WEST SUSSEX COUNTY COUNCIL CONSULTATION

TO:	Arun District Council FAO: Andrew Wood
FROM:	WSCC - Highways Authority
DATE:	10 April 2019
LOCATION:	Land adjacent to 2, The Grove, Ferring, BN12 5JA
SUBJECT:	FG/30/19/PL 1 No. new dwelling.
DATE OF SITE VISIT:	N/A
RECOMMENDATION:	Advice
S106 CONTRIBUTION TOTAL:	£N/A

This proposal is for the erection of a new 2-bedroom bungalow adjacent to 2, The Grove. The site is located on a privately maintained road; consequently these comments are for your advice only.

Drawing Title
005_01 Site & Block Plan
Land adjacent to 2 The Grove,
Ferring

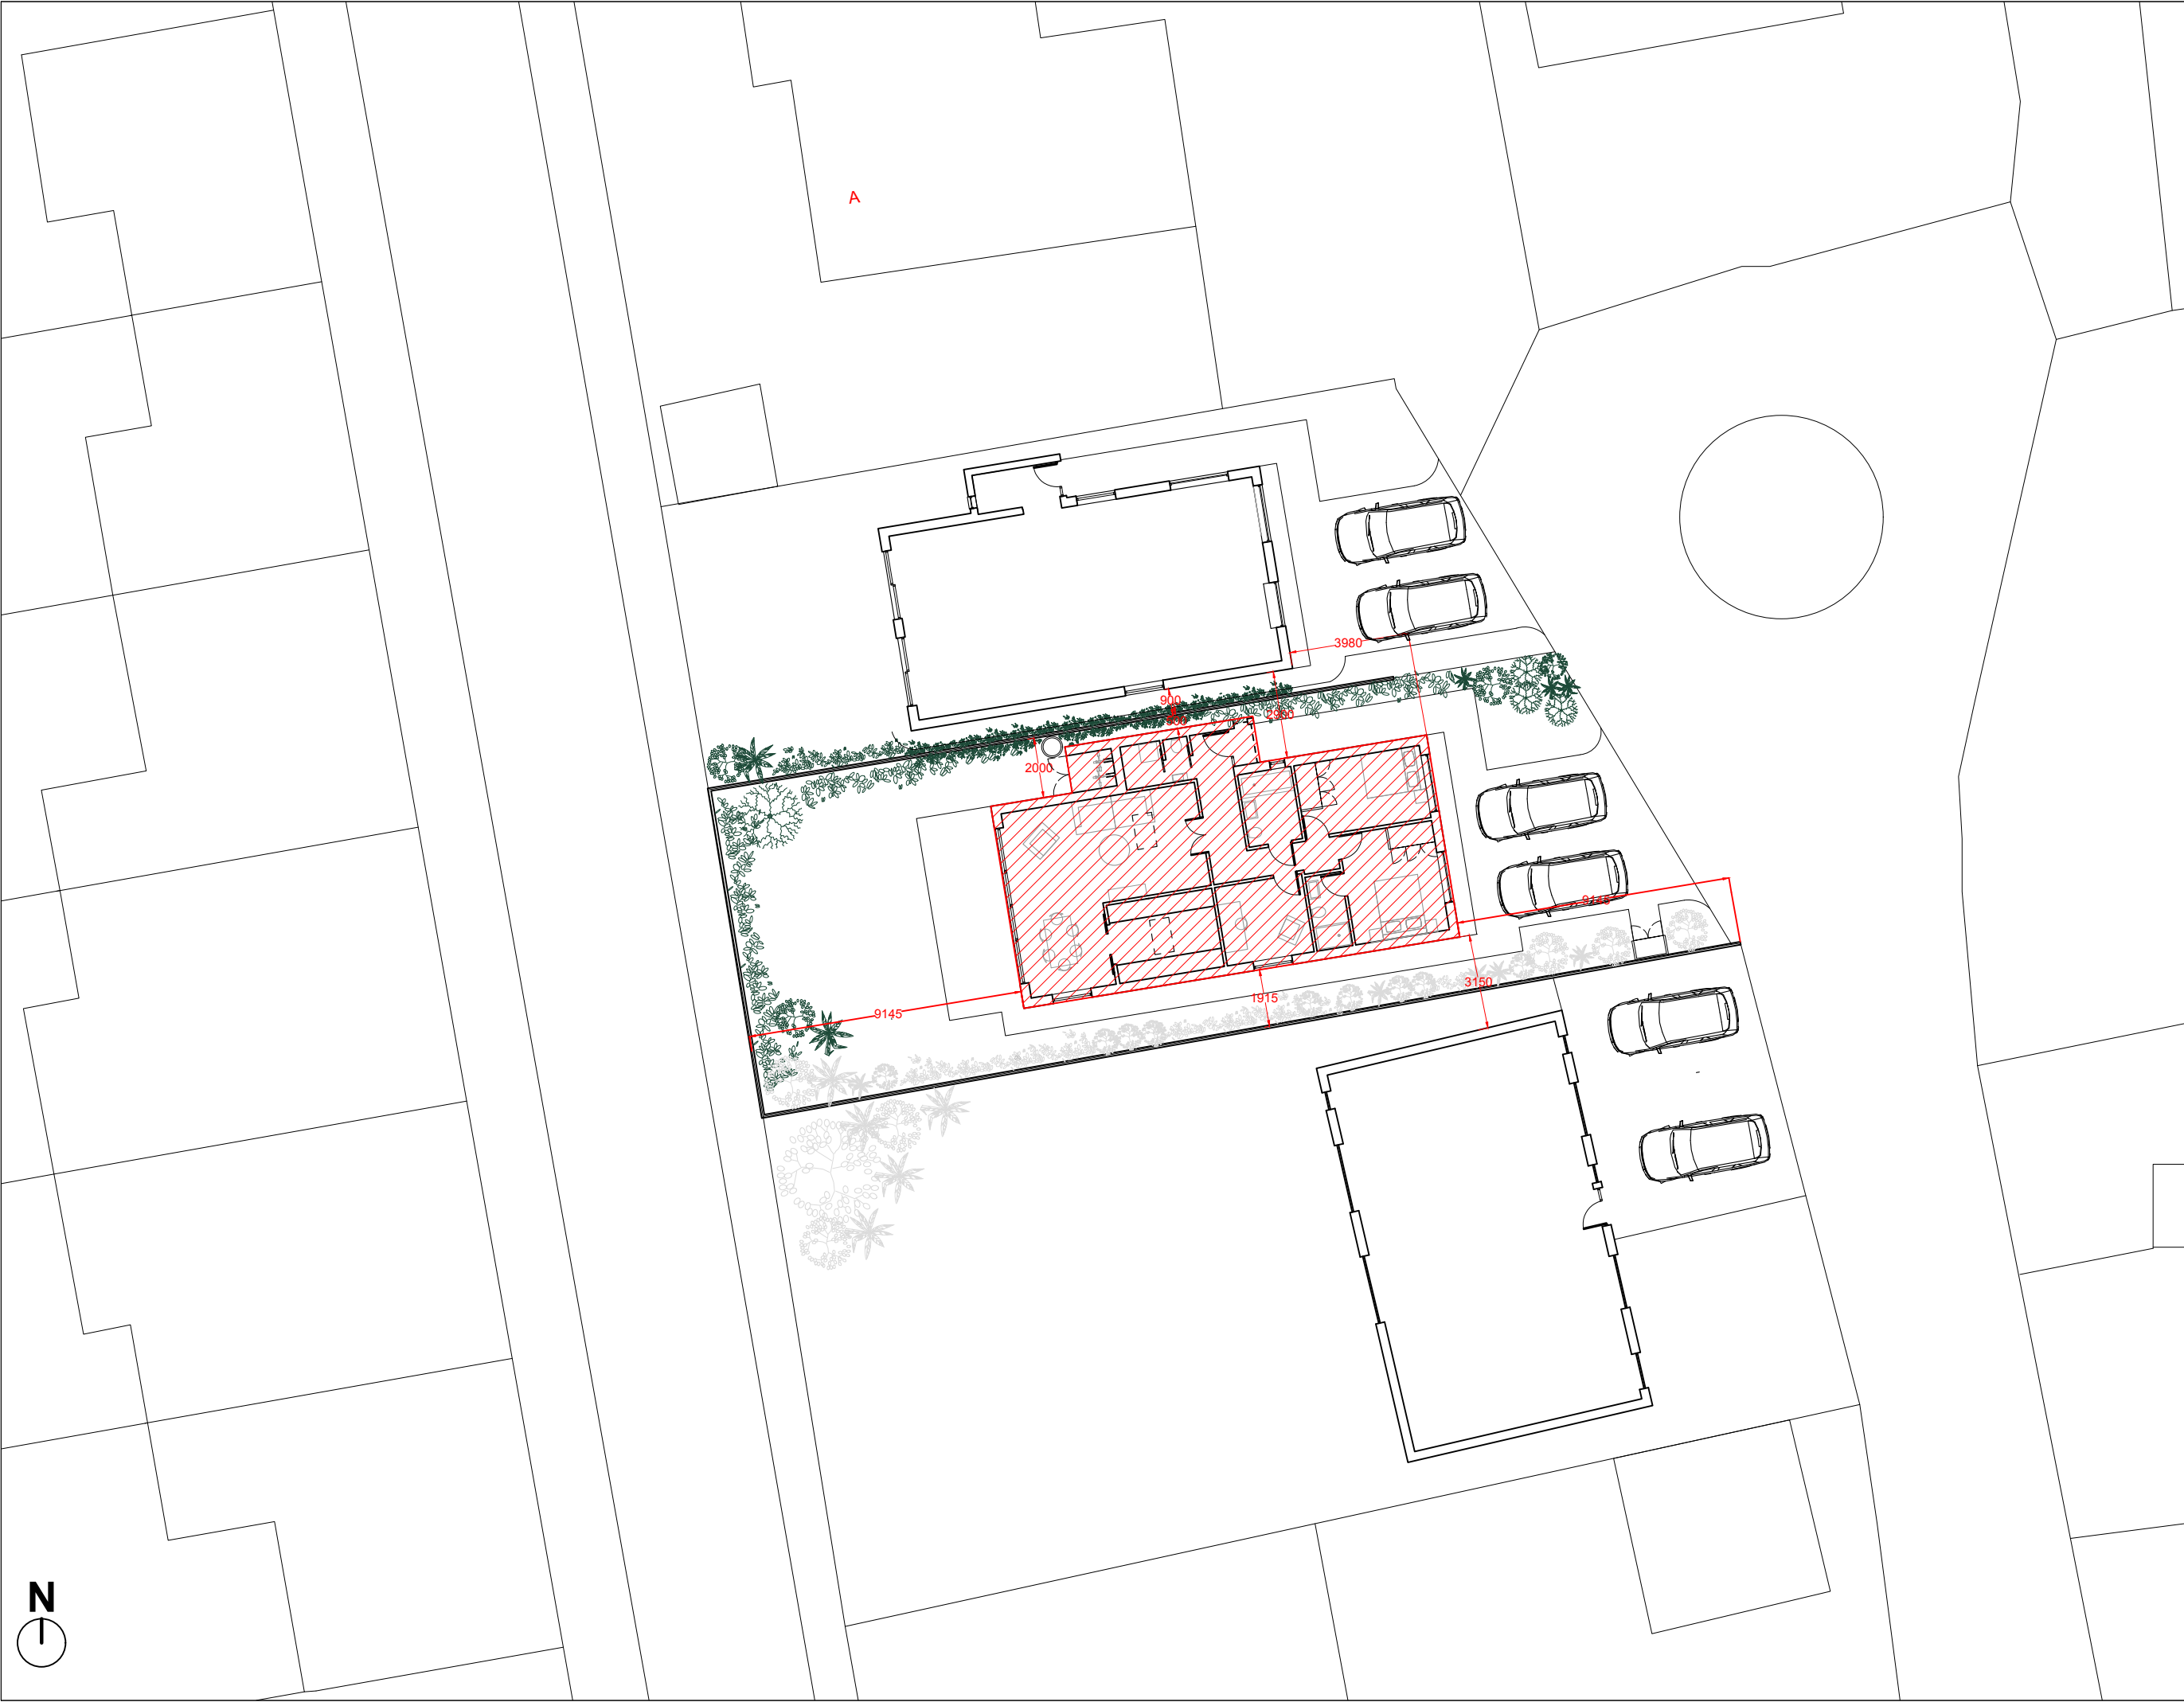
A driveway with space for 2 car parking spaces is provided in the plans. The WSCC Car Parking Demand Calculator indicates that a property of this size in this location would require 2 parking spaces. At least 2 cars could park sufficiently in the space provided.

Cycle storage has also been demonstrated in the plans. By including secure and covered cycle storage in the plans, this can improve the sustainability of the proposed dwelling by reducing the need to travel by car, and reduce car parking pressures in the local vicinity.

No part of the development shall be first occupied until covered and secure cycle parking spaces have been provided in accordance with the approved plan.

No part of the development shall be first occupied until the car parking has been constructed in accordance with the approved site plan. These spaces shall thereafter be retained at all times for their designated purpose.
